Wilby Manor Barns, Wooten Green, Wilby, Suffolk, IP21 5LB

Wilby Manor Barns have been granted planning and listed consent for conversion. Full planning and listed consent was granted under DC/21/04312 Planning and DC/21/04313 Listed Consent. The barns were in a state of partial collapse and at planning stage a structural engineer had confirmed safe access was not possible hence the conditions applied to the consents.

## Matters Arising from Heritage Visit During Construction

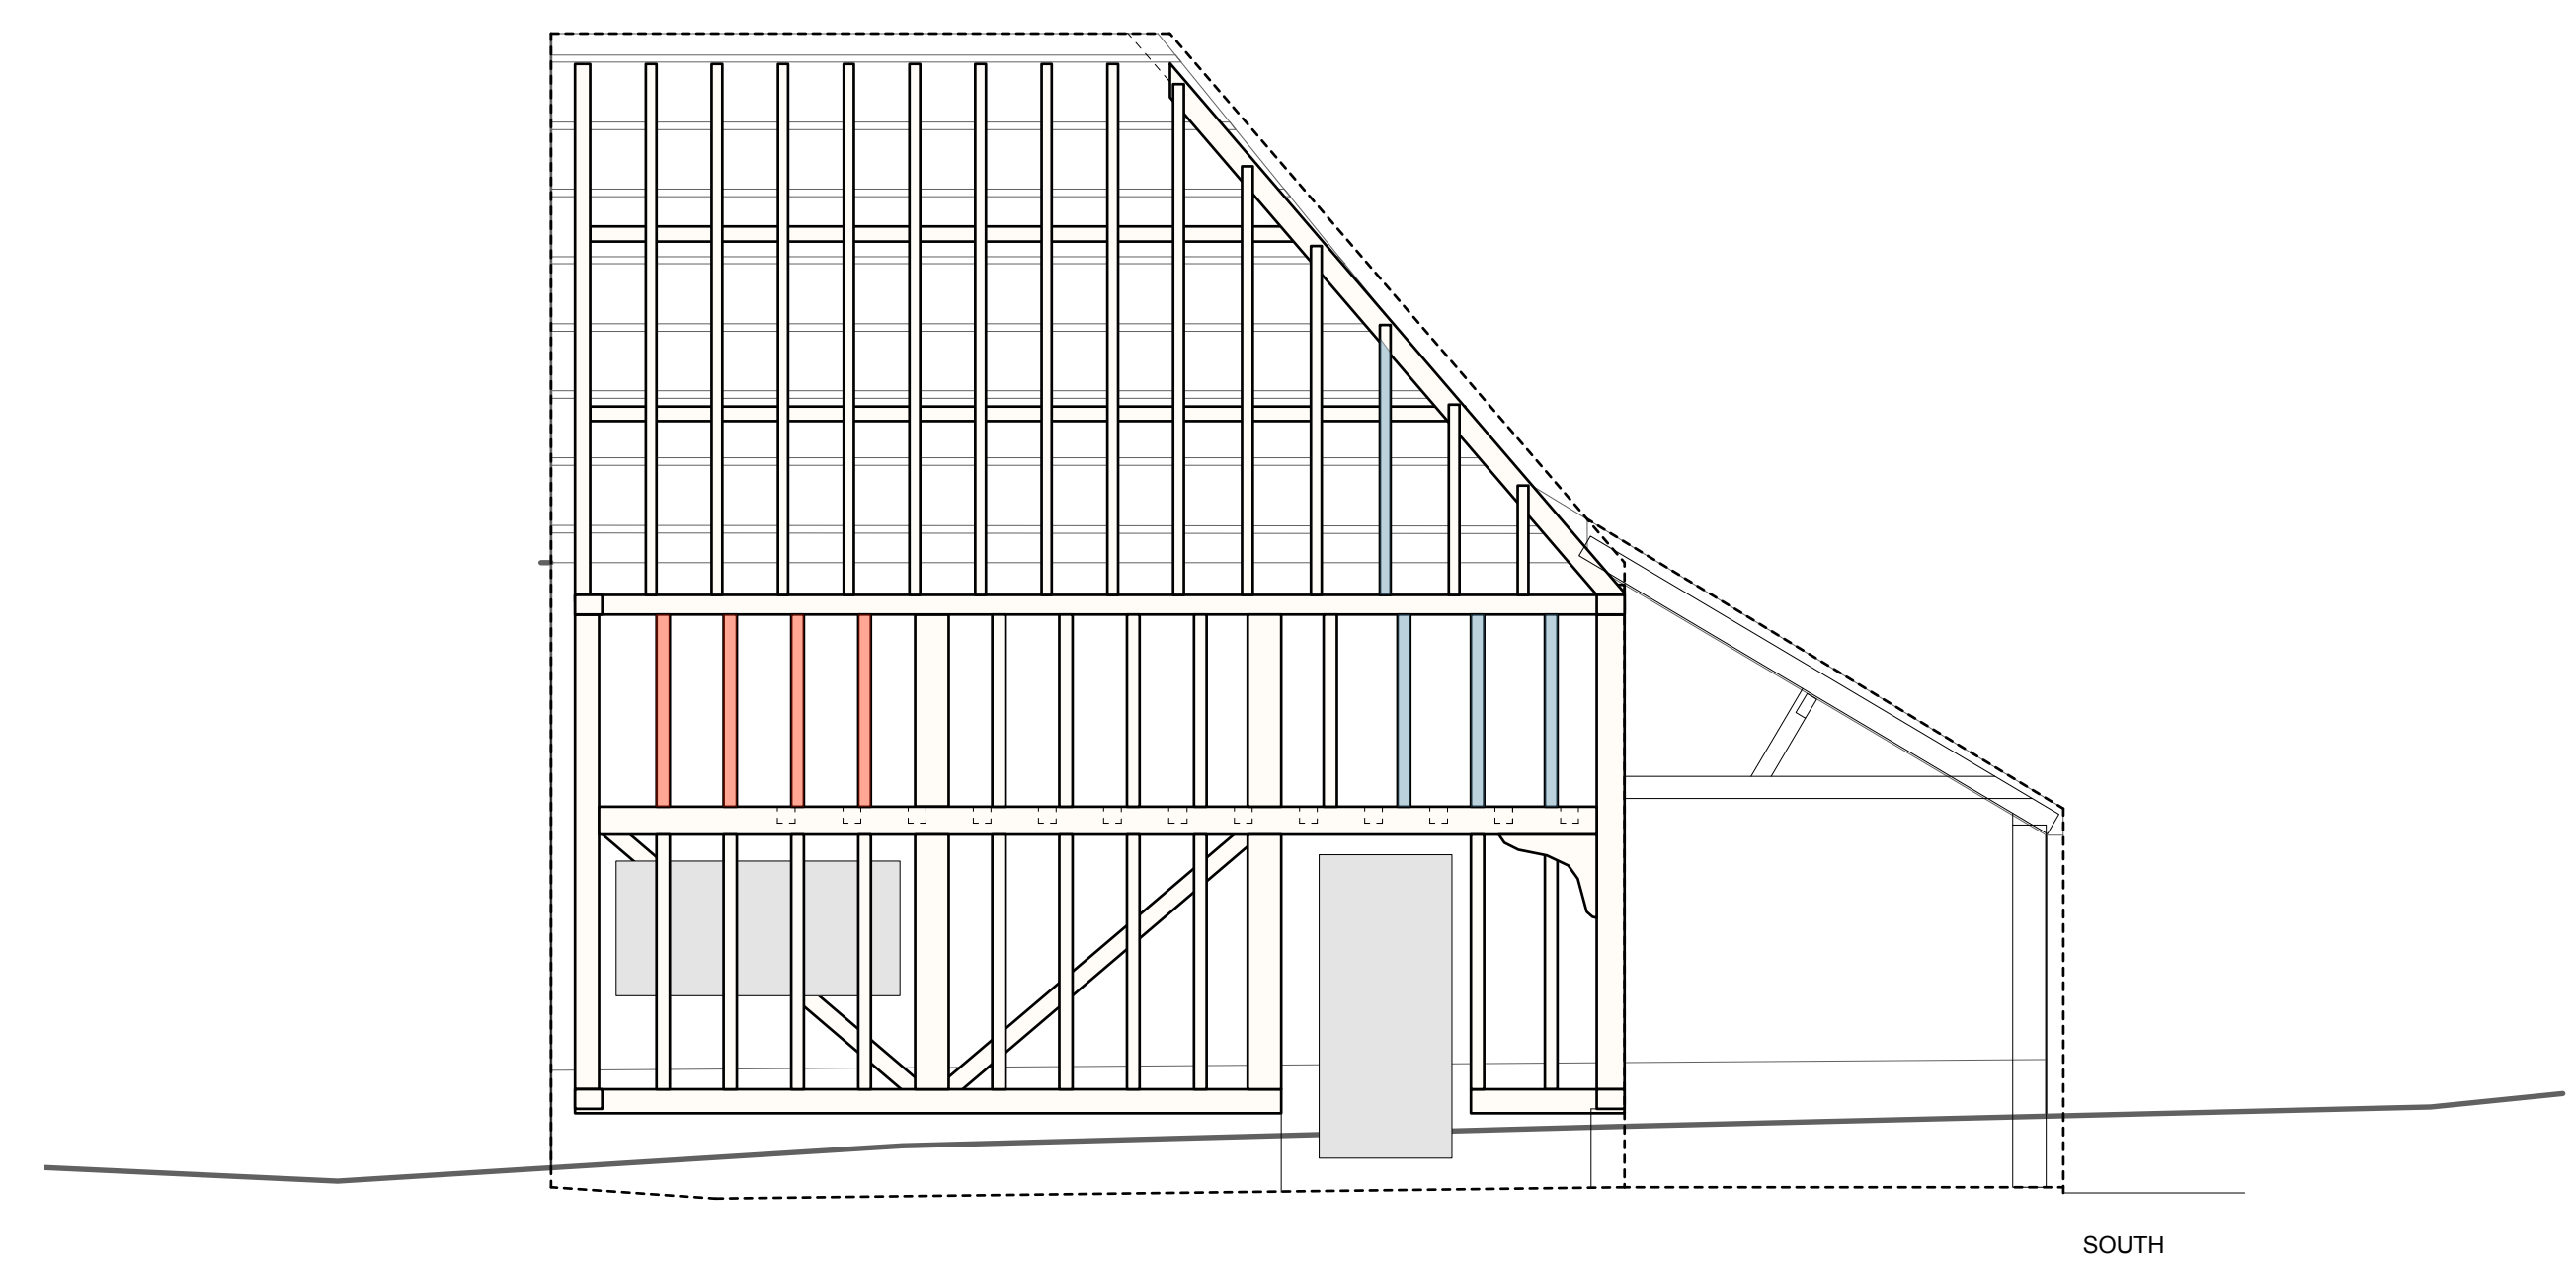
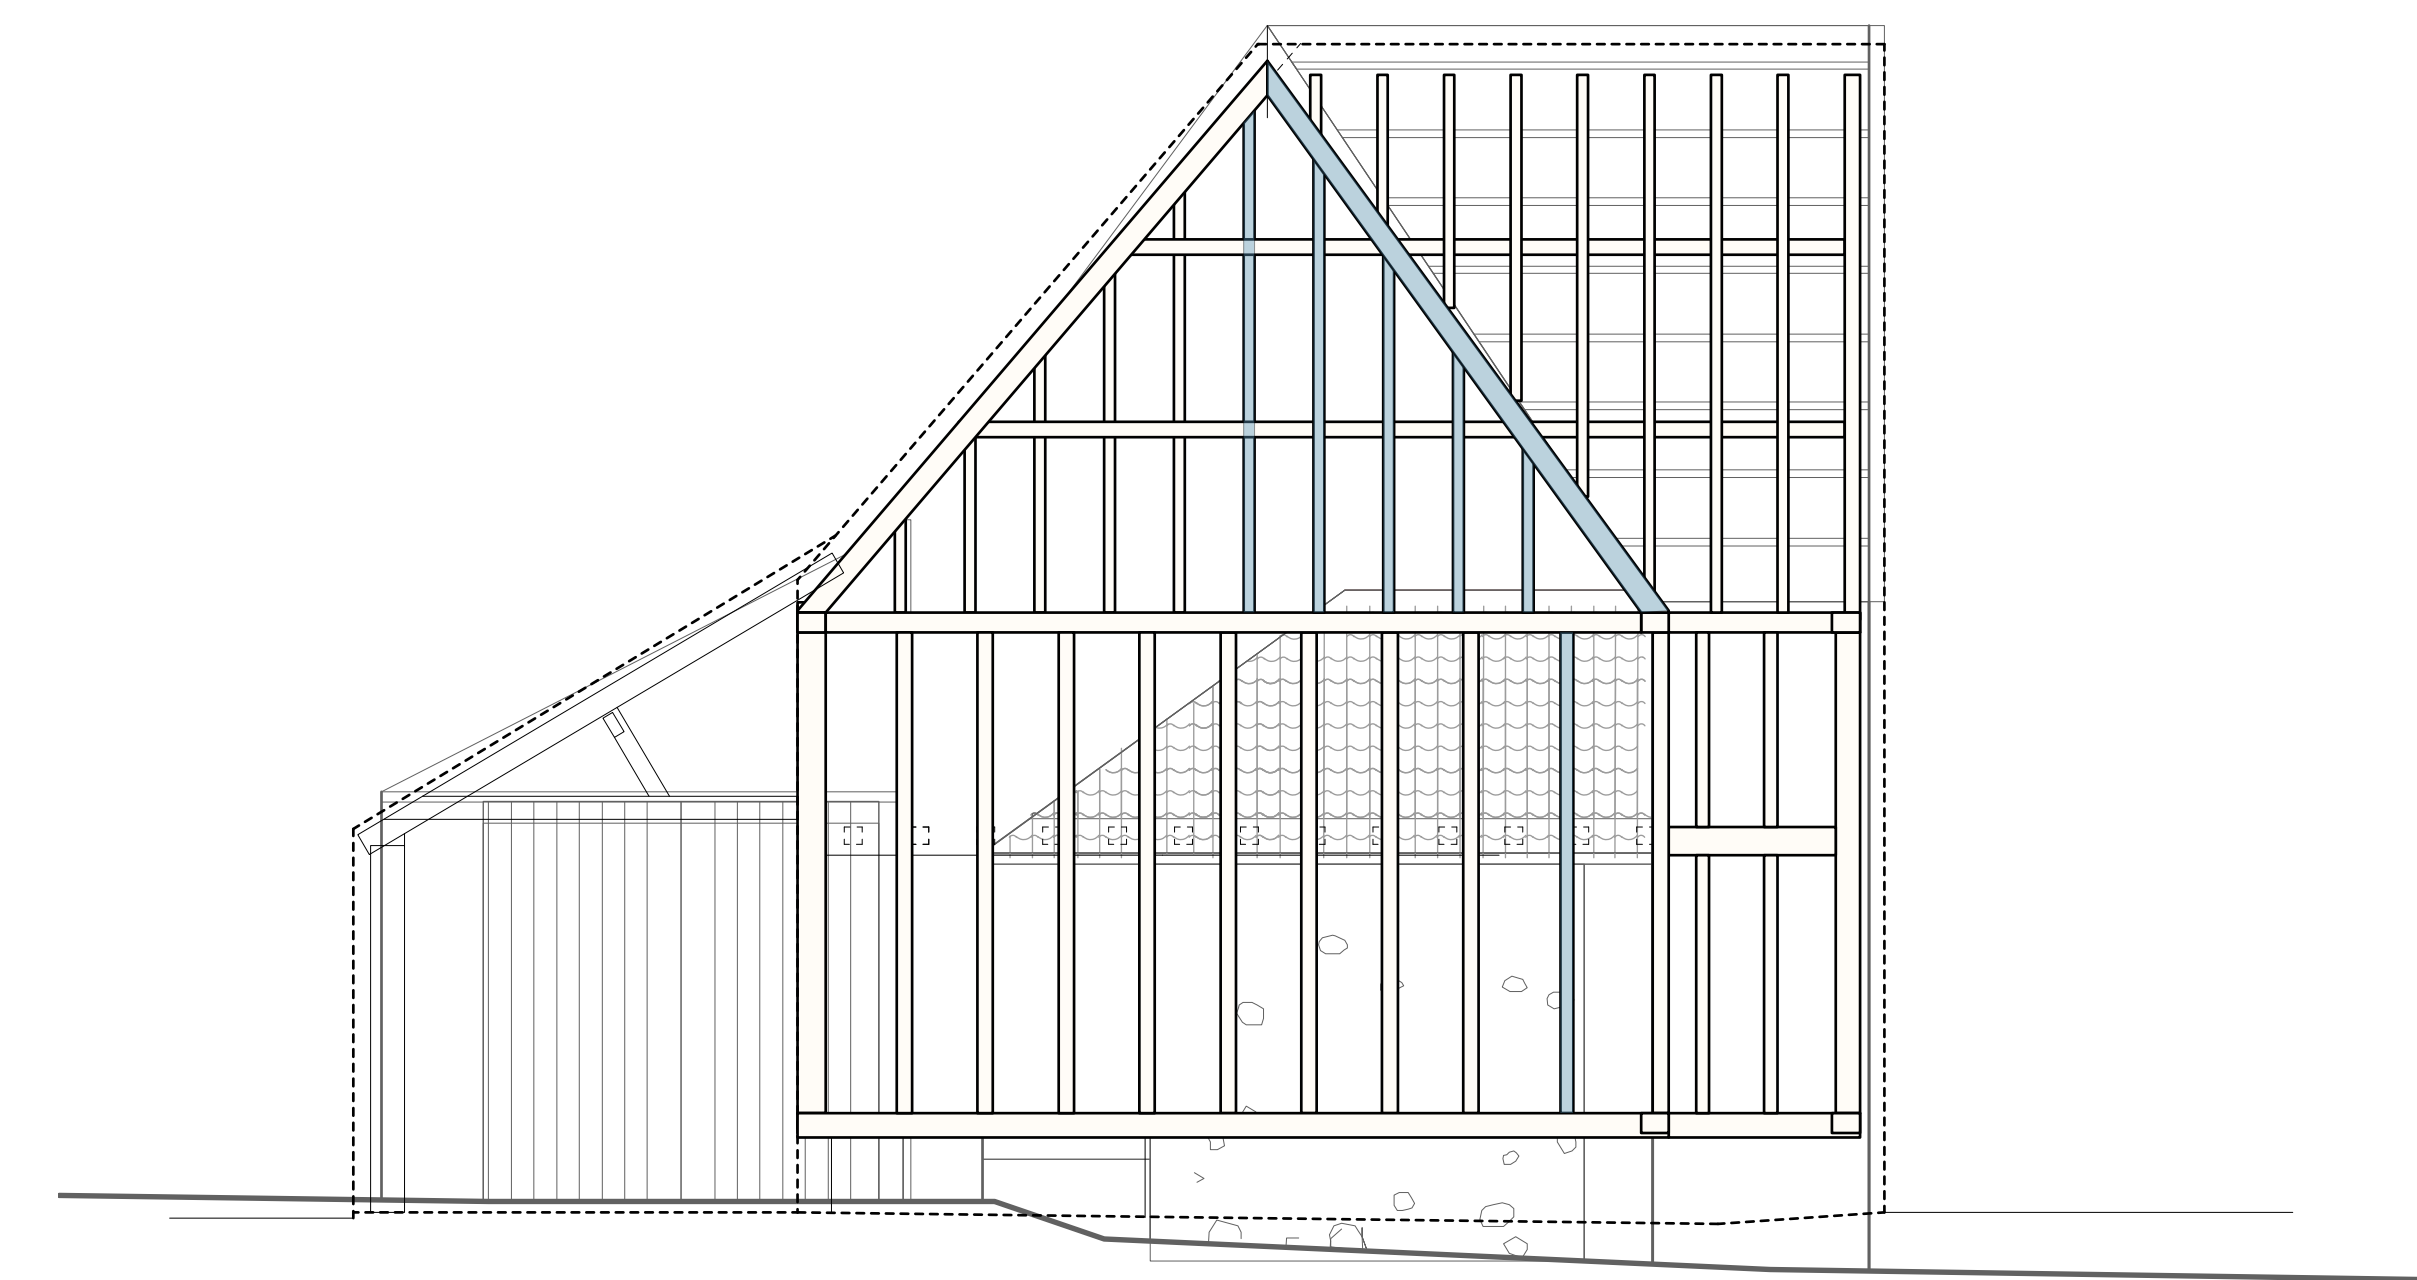
Condition 3 – Details of Timber and Brickwork Details – It was evident from the site visit that more timber frame repairs/replacement have been conducted than detailed under the current Discharge of Condition DC/24/00317. The condition wording requires agreement to “any repair of underlying timber frame and brickwork.” The drawing seen on site that seems to be being used in regard to the timber repairs, numbered R/21/052, does not seem to have formed part of the approval. The R/21/052 listed in the decision notice seems to be the attached document, which is not a drawing, nor a document I would consider a suitable schedule of frame repairs, hence the application of the condition. To start with, I would therefore request that you submit a further Discharge of Conditions application for this condition, or add to DC/24/00317, to retain these works, ASAP, detailing the other repairs/replacement conducted – for the extent of works seen on site, I consider that this would require measured frame drawings for the walls and roofs, making clear the extent of replacement, and any evidence you have at this stage to justify the need for the repairs conducted so far.

3) Floor Joists -The entirety of first floor joists across the barn have been replaced. I consider that these were of some historic interest. Again, limited evidence to justify wholesale replacement has been provided. Having viewed the limited extent of previous joists that had been retained on site, it was not immediately apparent that they were beyond retention, but they have been deliberately cut in order to remove them, and as such reinstatement of any of the previous joists now seems impractical. As above, I would however request detail of the methods used to install/fix the new joists to existing fabric.

We have attached drawings WD12, WD13 and WD14 showing all timber repairs and replacements across the scheme.

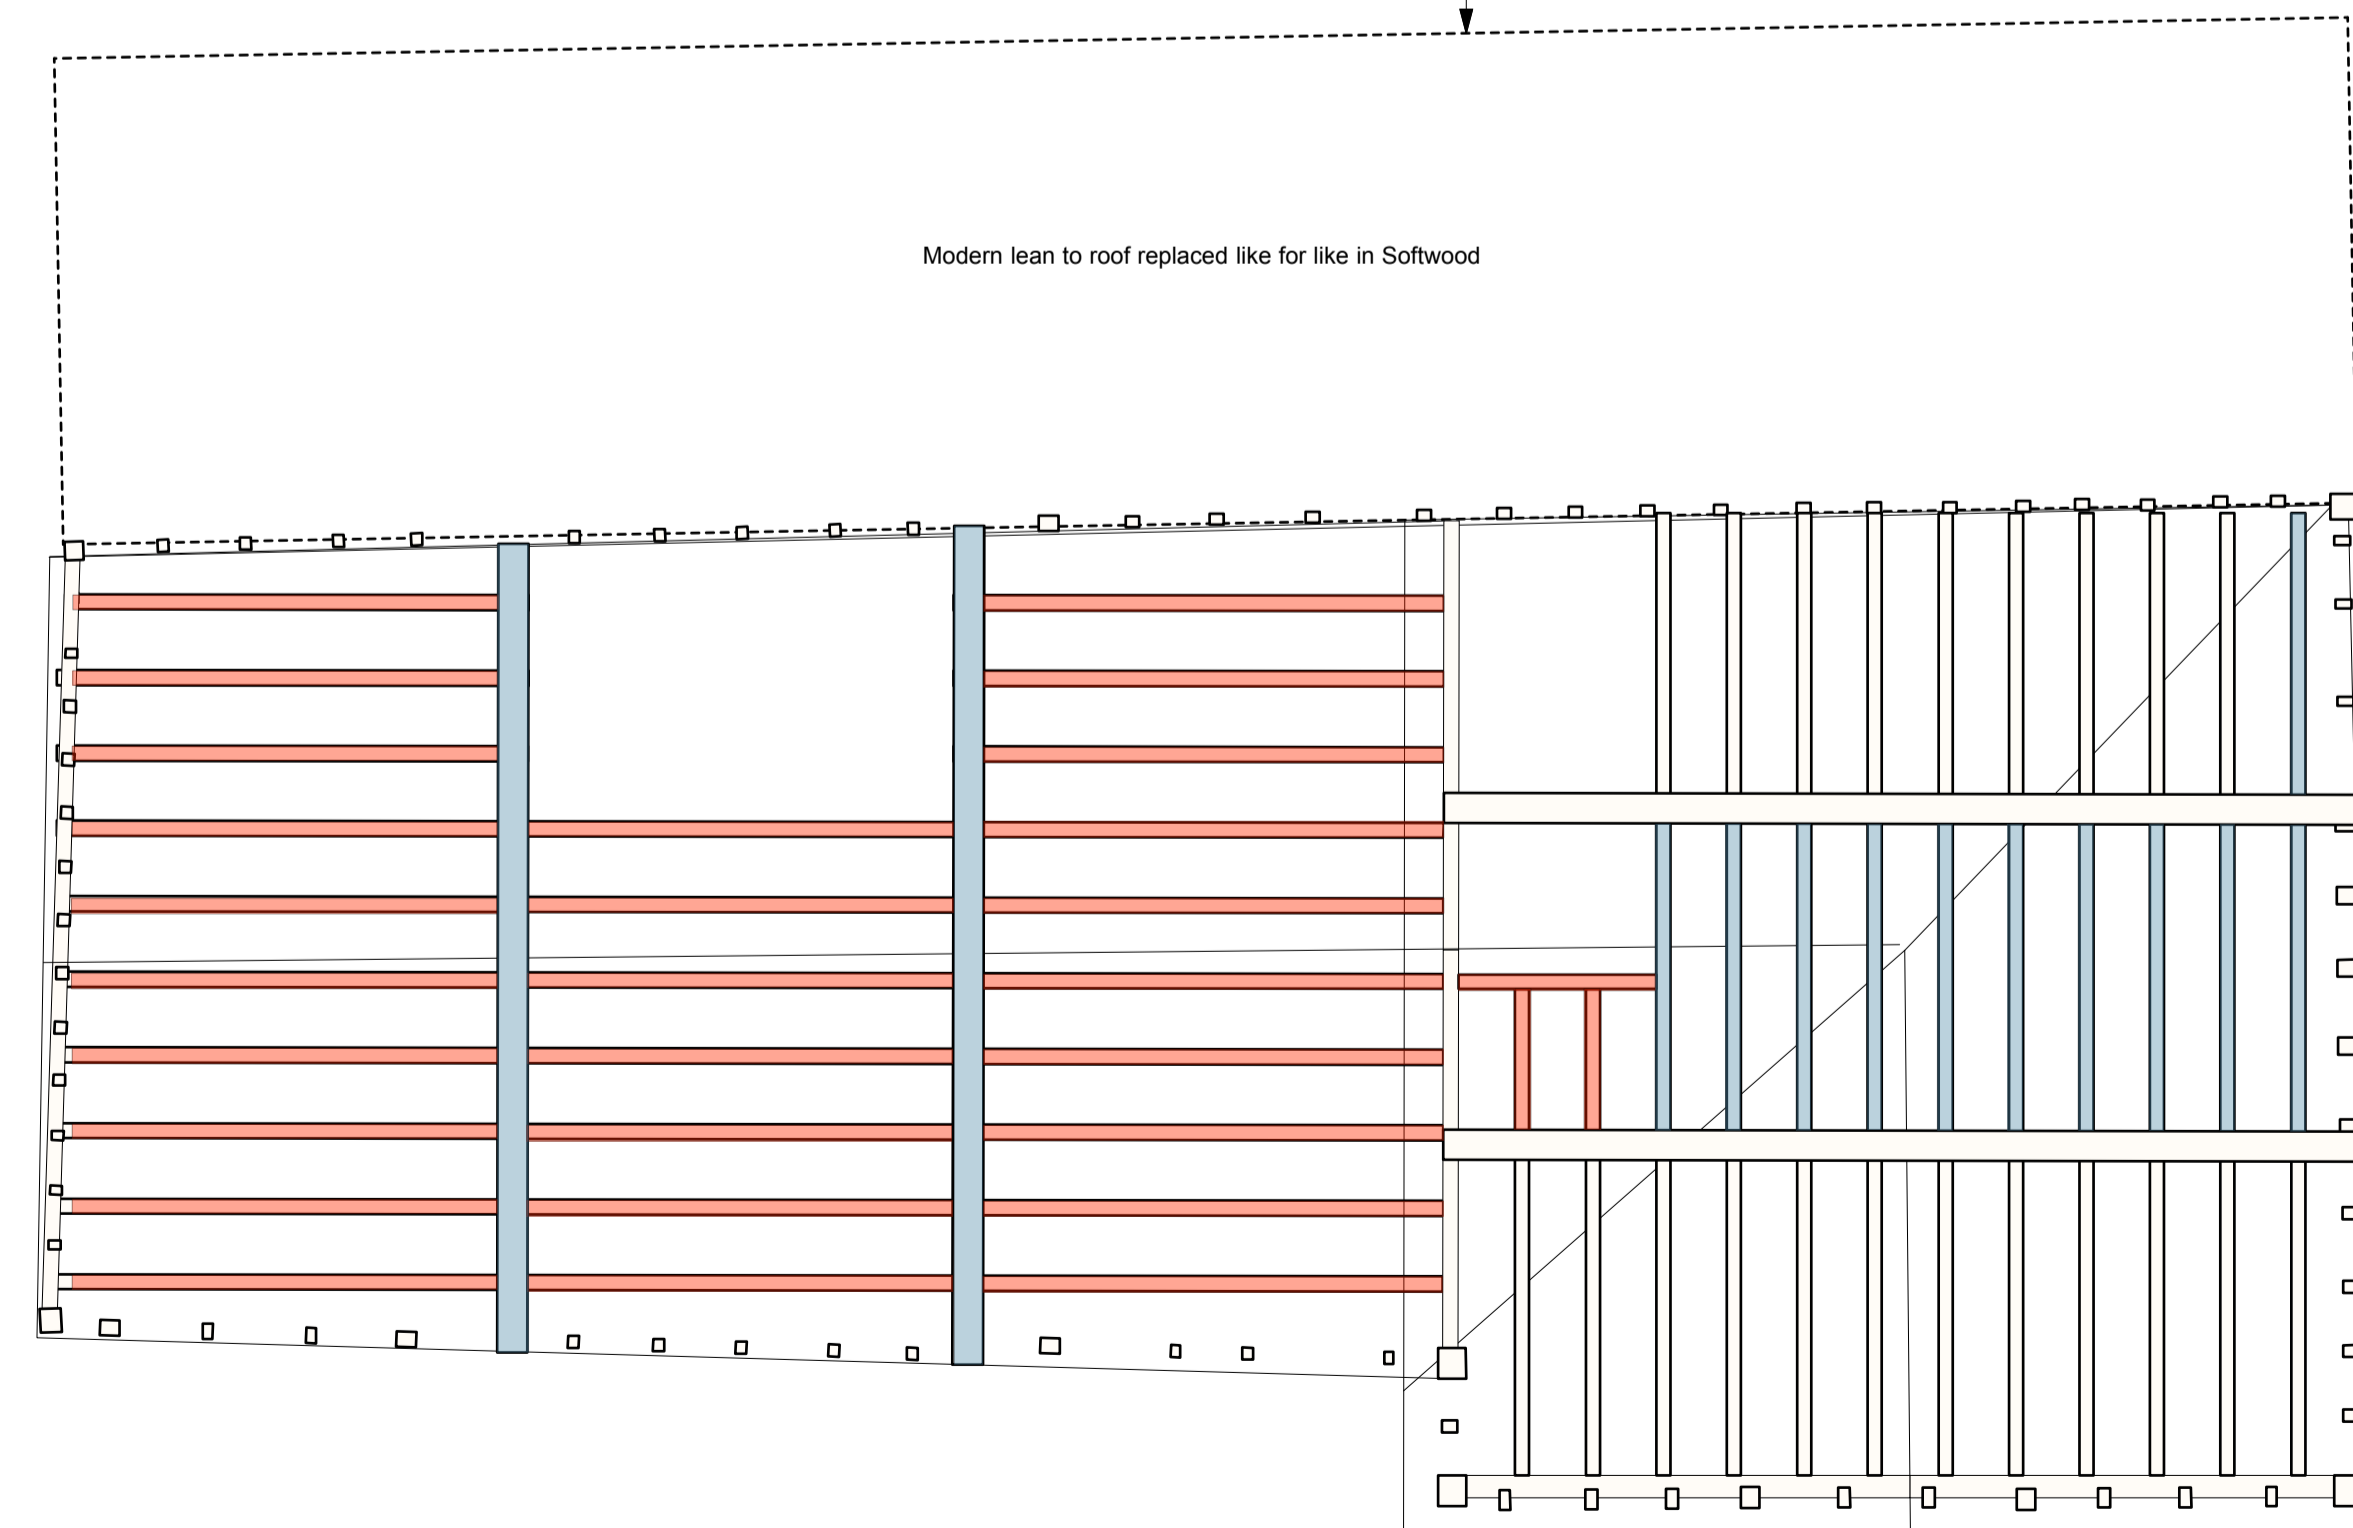
1) Wall Repair The two sections of the brick wall on the front elevation of the lean-to element have been rebuilt. This lean-to was likely a later addition to the barn, possibly of Victorian date, of lesser but possibly some historic interest. The brickwork itself was fairly traditional in form and materials. Limited evidence of the need for the brick walls to be entirely rebuilt has been submitted, but given the demolition has already been done, it cannot be undone, so there would be limited purpose in requesting this information. However, I do have concerns with the manner of the rebuilding and lack of details on the rebuilding. Firstly, the proposal should specify details of the mortar mix and bond used, and provide details of any shortfall additional bricks used alongside the existing, to include manufacturers literature and/or photographs of a sample, as appropriate. Secondly, the brickwork was previously painted, and this has been stripped, but this has resulted in an unsightly and untraditional messy external appearance to the bricks. I would advise that the bricks are further cleaned, and photographs to show the results submitted, but it may be determined that it would be more appropriate to repaint the brickwork, if a satisfactory appearance cannot otherwise now be secured.
